Longfield Solar Farm
Braintree District Council
UNR: LOSF-0003

BDC (LANDSCAPE SERVICES) Response to ExQ2 Question 2.2.3 (Veteran Oak Tree)

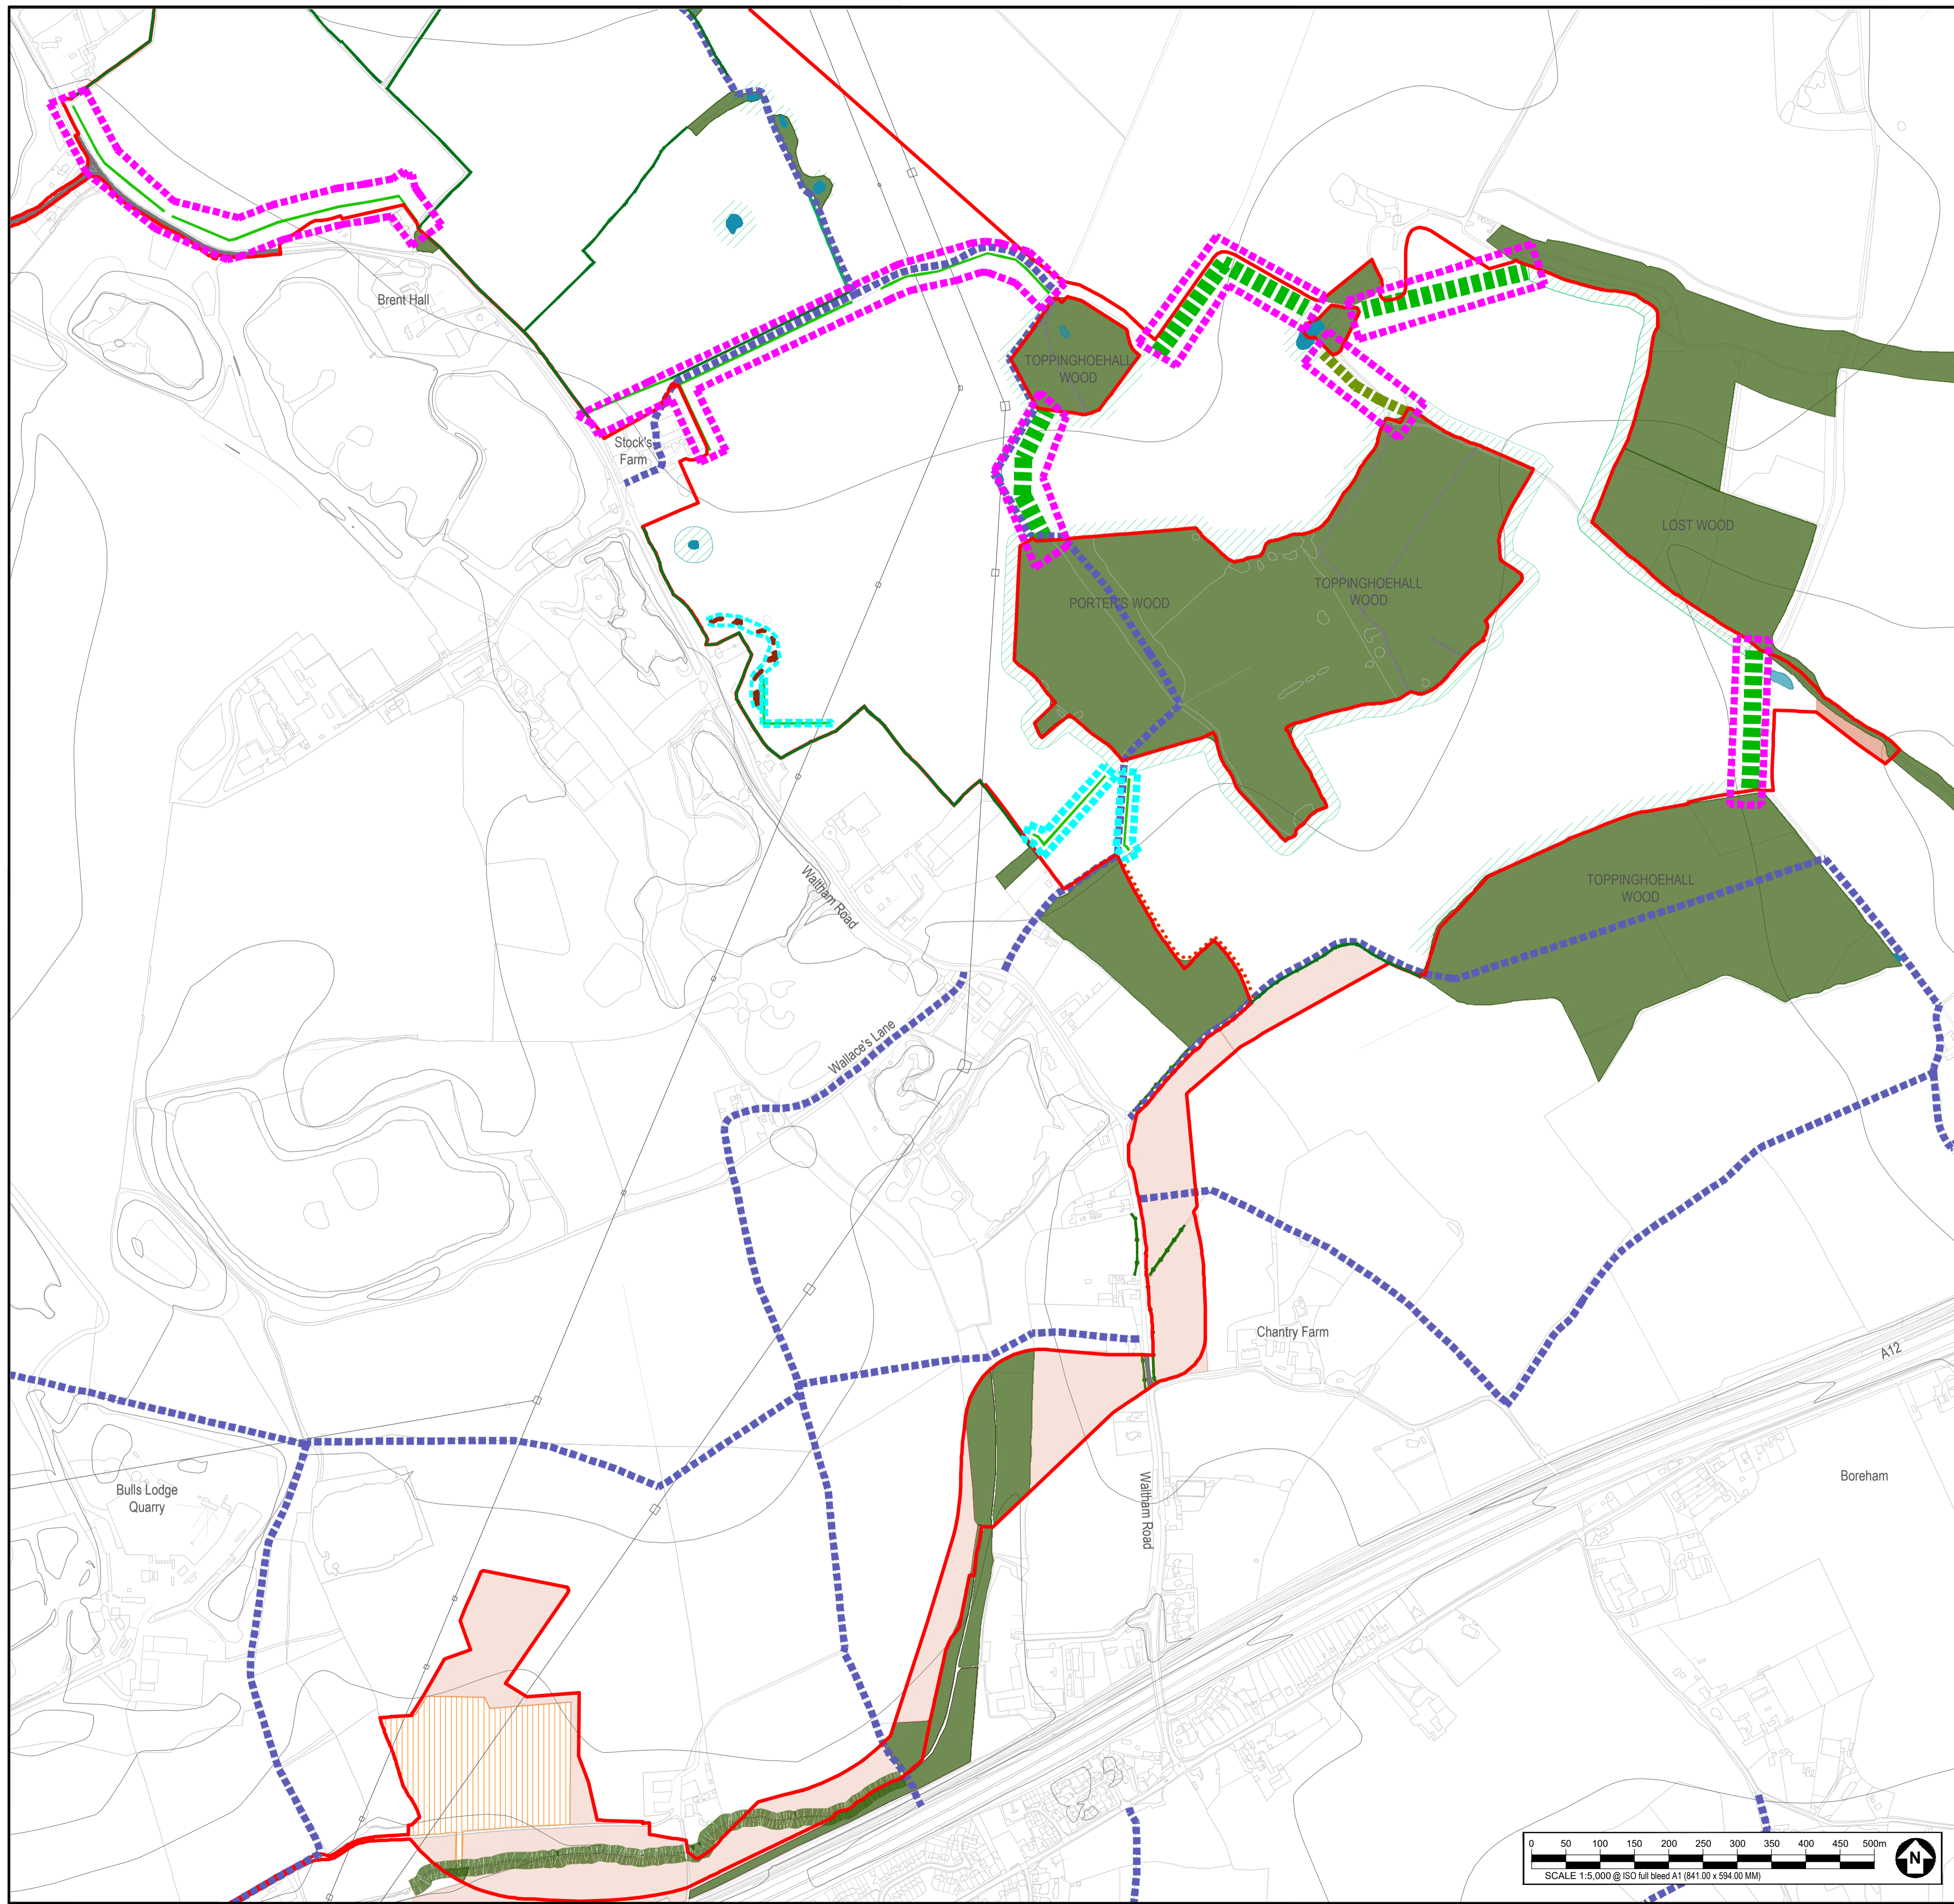
After reviewing the documentation submitted, namely the 'Arboricultural Impact Assessment (Part 1 of 2 & part 2 of 2)', the 'Illustrative Concept Design' (ARCUS), the Planning Inspectorate response, the 'Outline Landscape Masterplan – Advanced planting and Day 1 Solar Farm Construction' (AECOM), the 'Vegetation Removal Plan' (ARCUS) and the 'Biodiversity Net Gain Report' (tracked changes); BDC Landscape Services provide the following comments:

BDC Landscape Services echo these comments. The AIA suggests that the siting of the access track can be diverted around the veteran tree T9, to avoid conflict. However, there is no supporting documentation to be found to show any alteration to the track to avoid this significant tree. The vegetation removal plan shows the vegetation at the location of T9 as being removed for access, with no indication that the tree exists. The same is true of the Illustrative Concept Design, and no mention of the veteran tree can be found within the LEMP or the BNG report. Disparity is apparent and the veteran tree is being ignored.

FIGURE NUMBER  
Figure 2-5

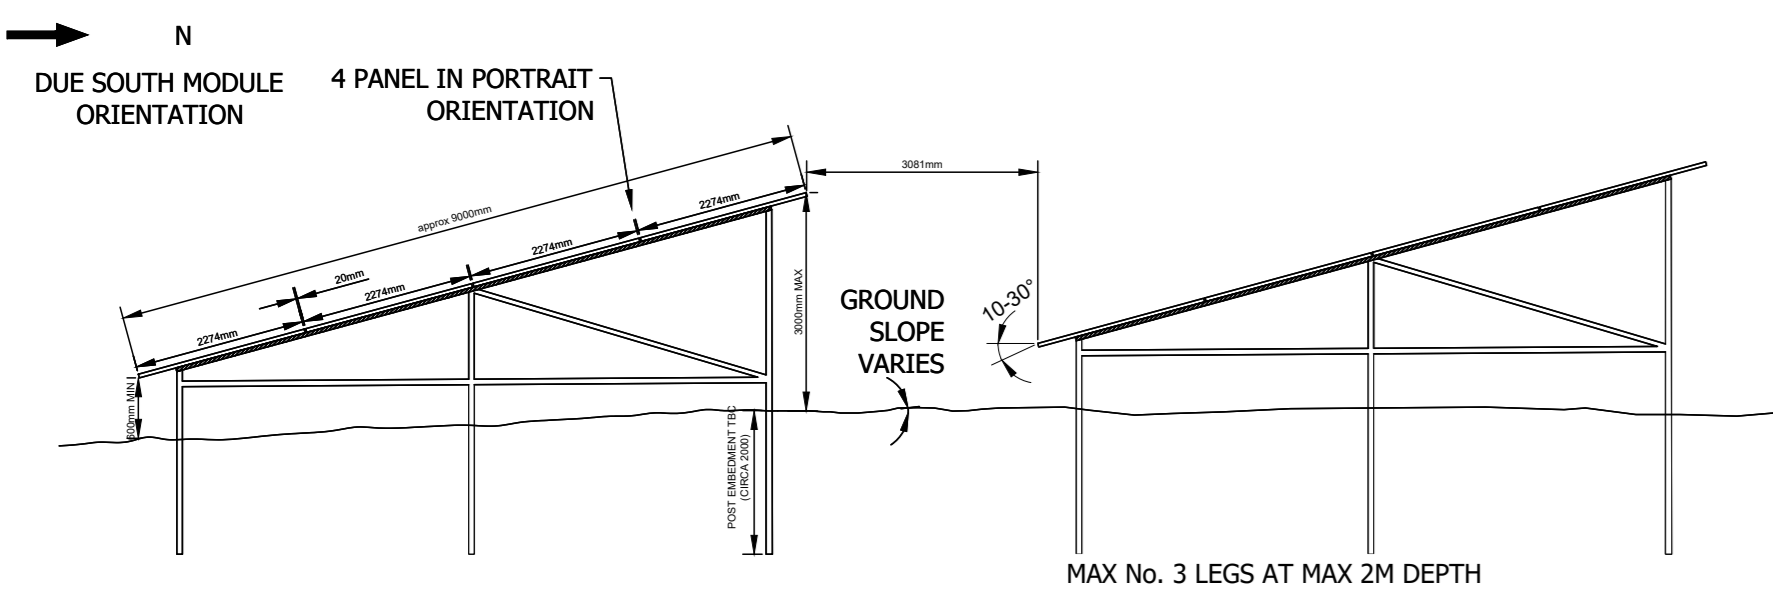
The AIA offers suggestions for mitigation of the impact to T9, and it is felt this should be adhered to and adopted within further updated submitted vegetation removal plans and the illustrative design concept.
